BUILDING PERMIT

Located At 21 MARSHALL ST UNIT #5

Job ID: 2011-08-2121-ALTCOMM

has permission to Replace a section of rotted guardrail

UNIT #2 FROM PLOT PLAN

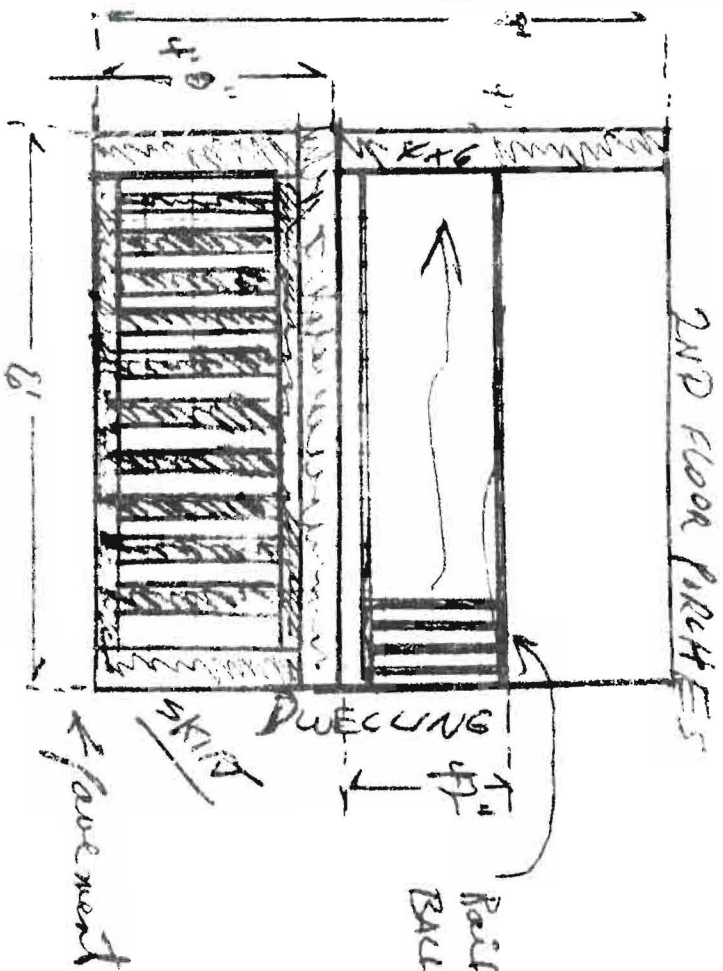
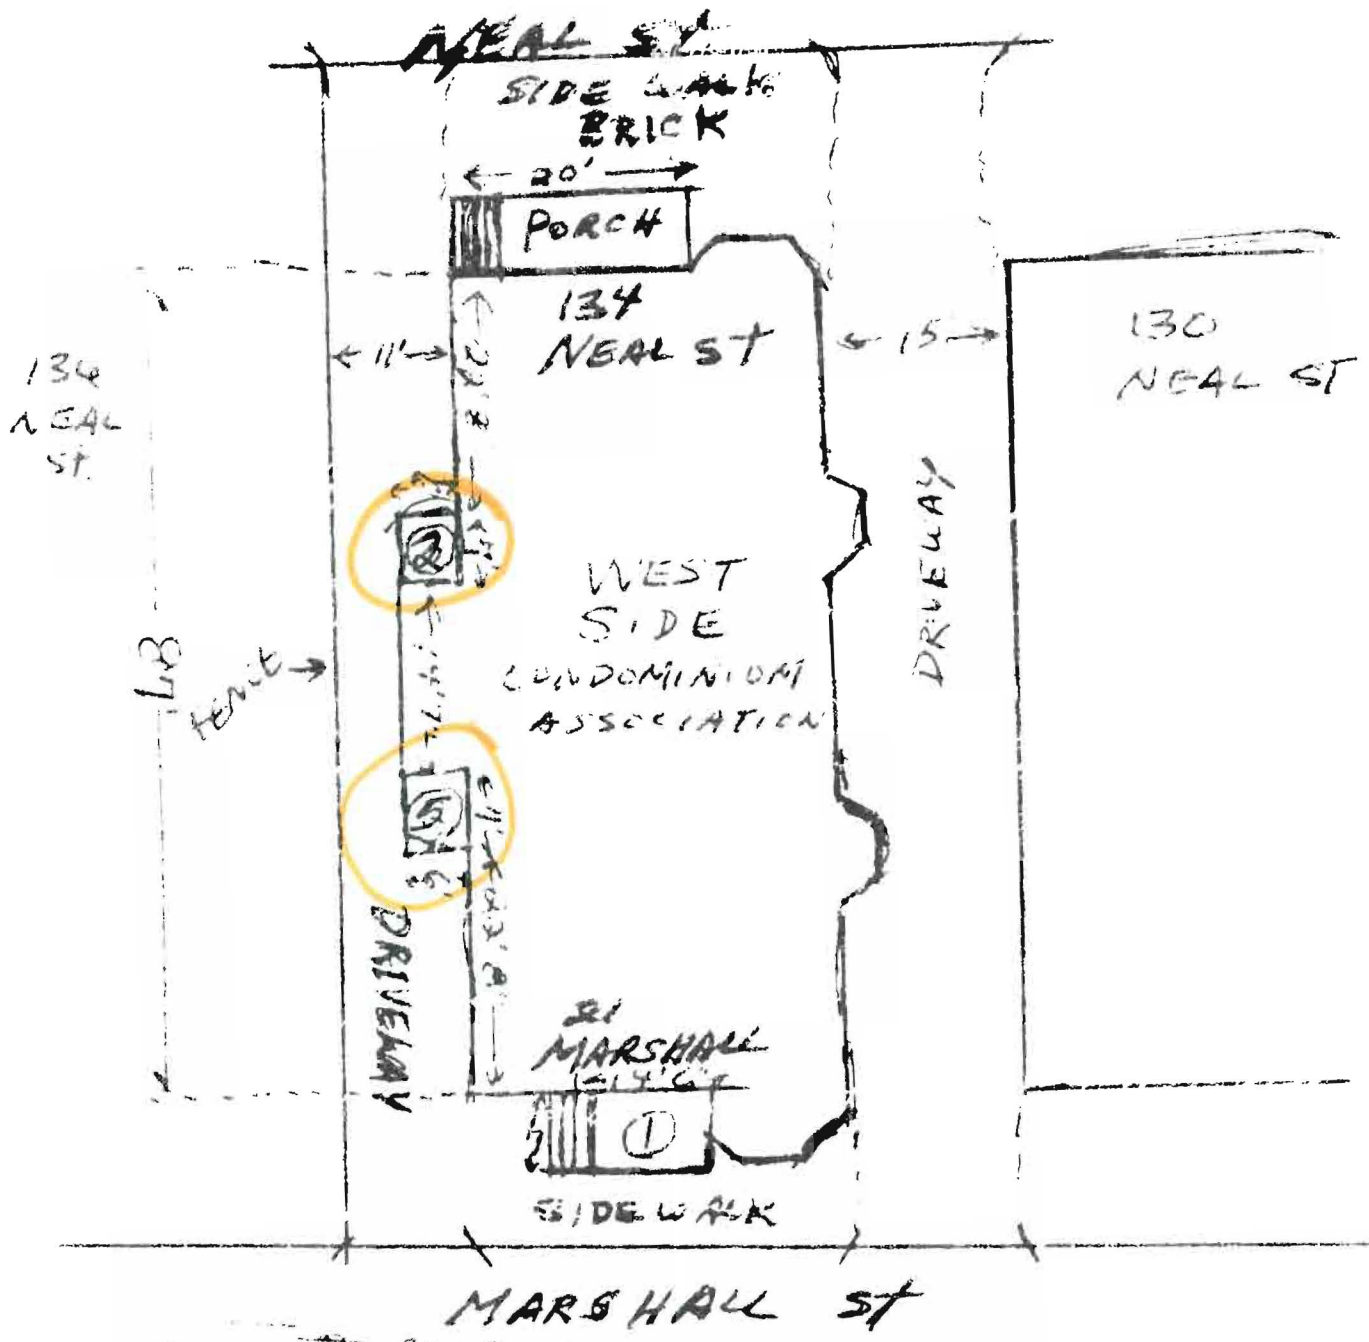
1. Railing height not to exceed 36" to be consistent with traditional railing heights and proportionate to existing building.

1. Application approval based upon information provided by applicant. Any deviation from approved plans requires separate review and approval prior to work.
2. This permit is approved per IBC 2009 Section 3409.1 for existing historic buildings; guardrail height allowance is 36".

Historic Preservation Committee/Staff Recommendation: Staff does not
support 42" railings in this
context - recommends 36"
 Inspections Staff Recommendation: OK for 36" HT
